ABP Reference: PA08.318540

Re: Response to Kerry County Council Submission

10 year planning permission for the proposed Open Cycle Gas Turbine (OCGT) power plant fuelled by Hydrotreated Vegetable Oil (HVO) and associated site works at Tarbert Island, Tarbert, Co. Kerry.

To SSE	Project name Tarbert Bio-fuel Plant	Project number 60695232	Client SSE
Subject Technical Note (Flood Wall)	Date 21 March 2024	Document ref TN TBP/001	Issued by AECOM
Reason for issue Response to Chief Executive Report for Tarbert by Kerry County Council	Prepared by Various	Checked by Sreeraj Menon	Approved by Peter Neville-Jones
Revision No. 03

Proposed Overall Site Plan
1:2000
Sheet 1 of 3

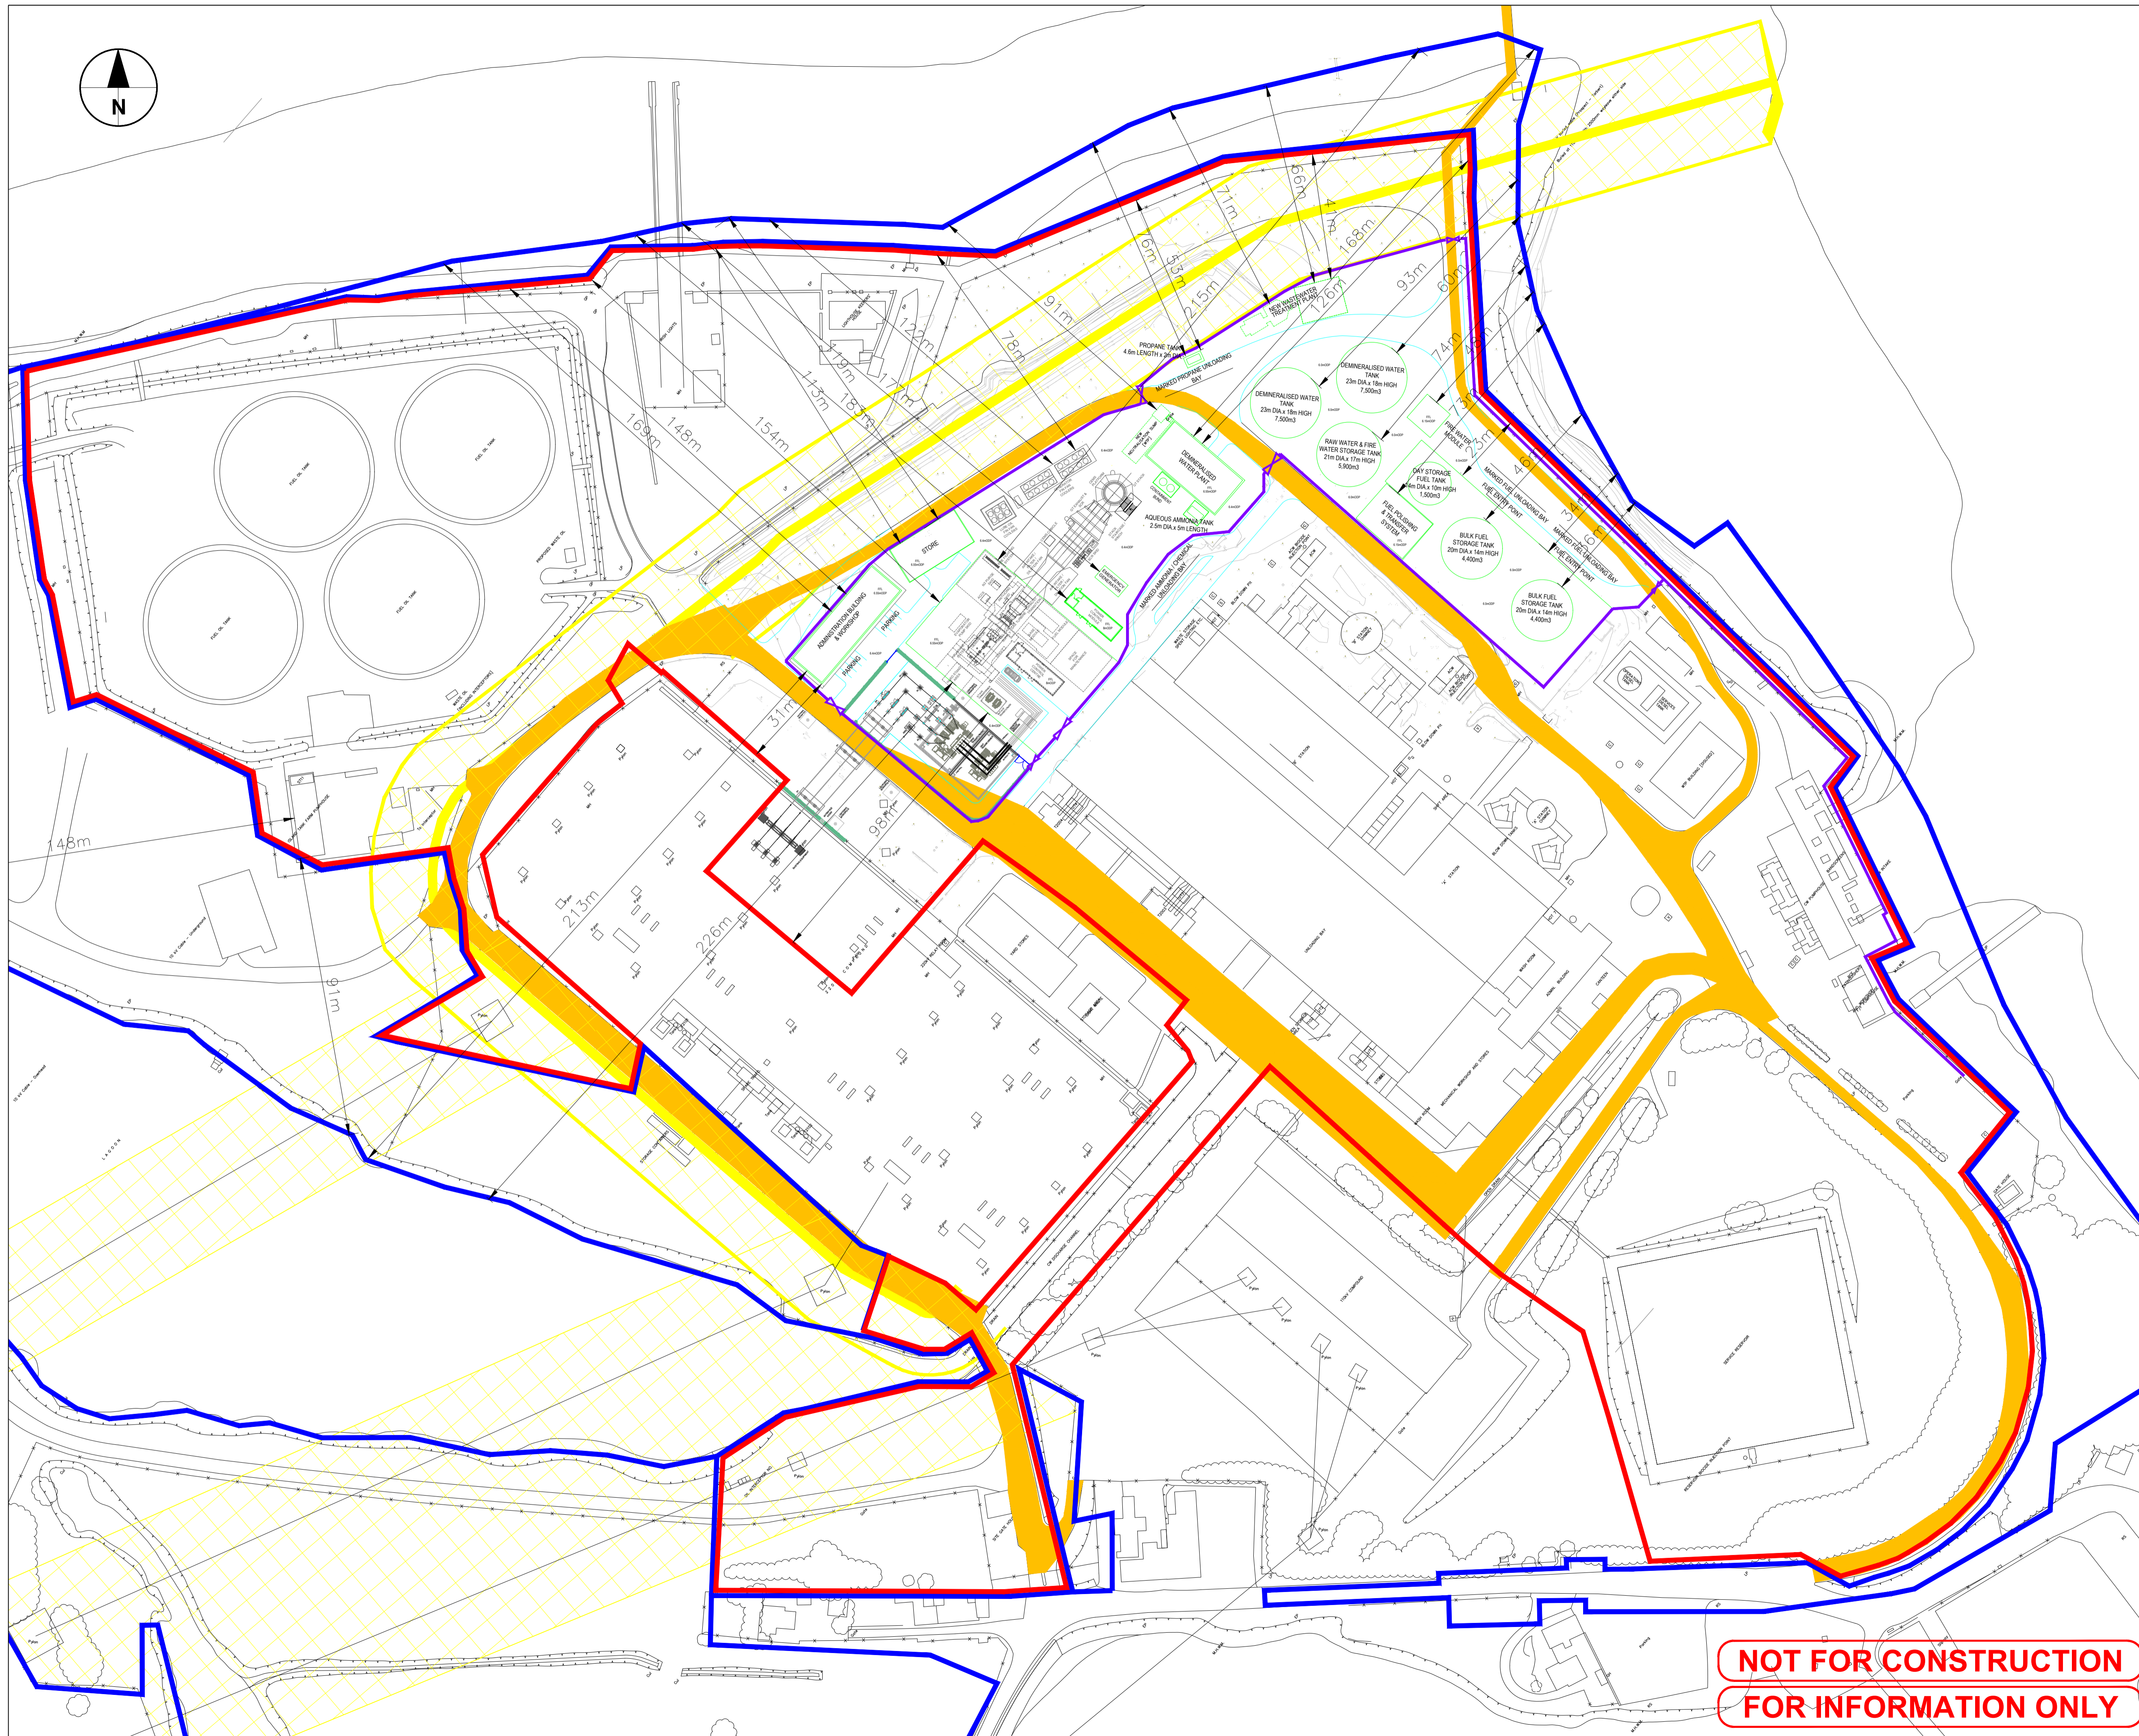
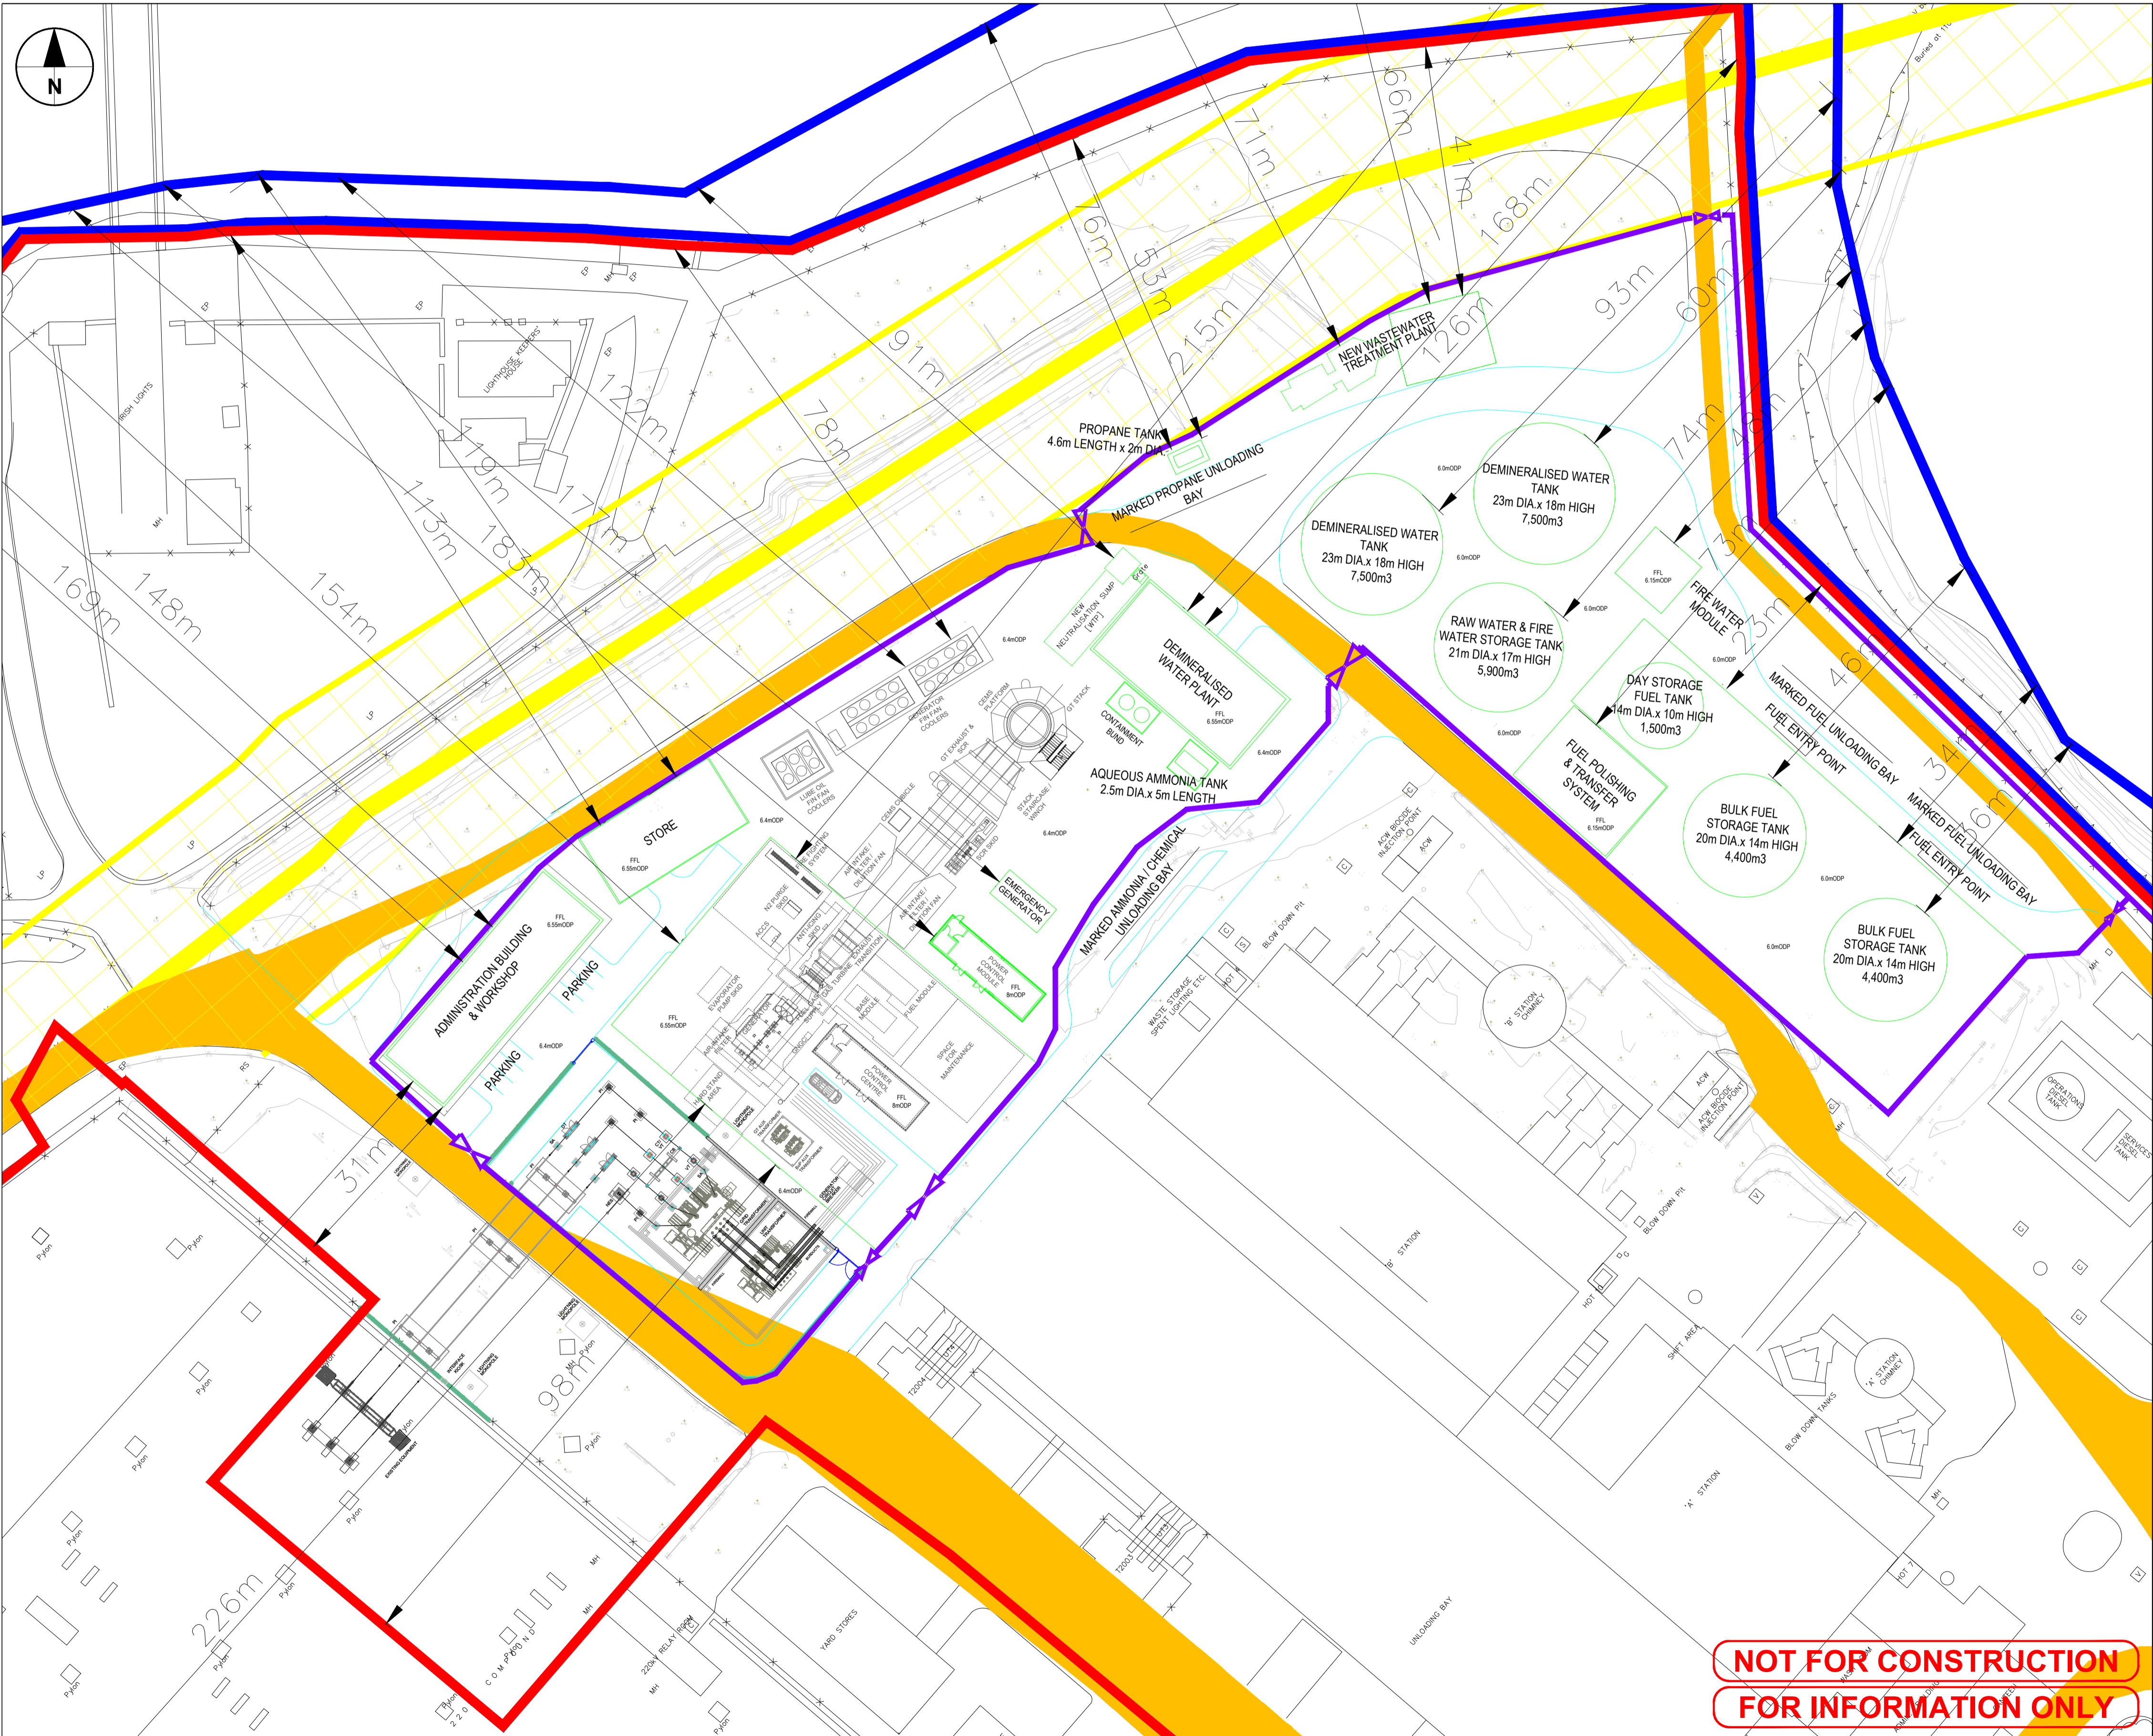
<p>The Coastal and Flooding Unit recommends that it would be prudent to design for the more conservative Option 3, which requires an increase in the height of the Flood Wall/Gate.</p>	<p>The 'Option 3' that is referred to, from the initial Flood Risk Assessment (Appendix 12A of the submitted EIAR), relates to an extended design life for the Proposed Development. It provides for sea level rise up to the year 2100, which would equate to a design life of c. 70 years. This is well in excess of the 25-year design life that is being applied for. The flood wall crest level that is proposed, of +7.54 ODP, provides a suitable standard of protection for the 0.1% AEP extreme water level based on a 25-year design life (plus a 5-year decommissioning period) and the latest assessment of future sea level rise.</p> <p>It should be noted that a pragmatic design approach has been adopted for the proposed flood defences, which can be adapted in future (i.e. by increasing the flood wall crest level), if required, to allow for either a potentially modified design life or a more rapid than predicted rate in future sea level rise.</p> <p>Please refer to the enclosed 'Flood Wall Technical Note' prepared by Aecom, which provides a summary of relevant information contained within the submitted EIAR.</p>

Kerry County Council (KCC) has requested further justification for setting the height of the proposed flood wall at an elevation of +7.54m ODP and has requested that this is raised to +7.90m ODP. The level of +7.54m ODP is 0.04m higher than that proposed in the Updated Coastal Flood Risk Assessment (Mott MacDonald, 2020) which notes that the new defences would be up to 1.5m above existing ground levels and typically only 1m higher. Raising the crest of the flood defences to +7.90m ODP would therefore increase their height to between 1.4m to 1.9m above ground levels.

As shown in Table 5, the refined estimate of sea level rise results in a design crest level for the flood wall and other flood defence structures of +7.51m ODP for a 25-year design life. This is marginally lower than the +7.54m ODP indicated on the design drawings. The reason for this minor discrepancy is the slightly conservative approach previously used to estimate future sea level rise.

The analysis presented in this note is based on the latest available information and guidance and adopts a conservative approach at each stage. It is concluded that the previously advised flood wall crest level of +7.54m ODP provides a suitable standard of protection for the 0.1% AEP extreme water level based on a 25-year design life and the latest assessment of future sea level rise. However, should an extended design life of 50 years be required, a further raising of the flood wall crest height by approximately 0.5m would be required with an associated cost increase that would be in excess of the 20-25% referred to in Section 3 above.

To mitigate uncertainties associated with future climate change, a pragmatic approach is recommended by adopting a design approach that can be adapted to allow for either a potentially modified design life or a more rapid than predicted rate in future sea level rise. Periodic reviews during the lifetime of the project would also form part of this future proofing approach.
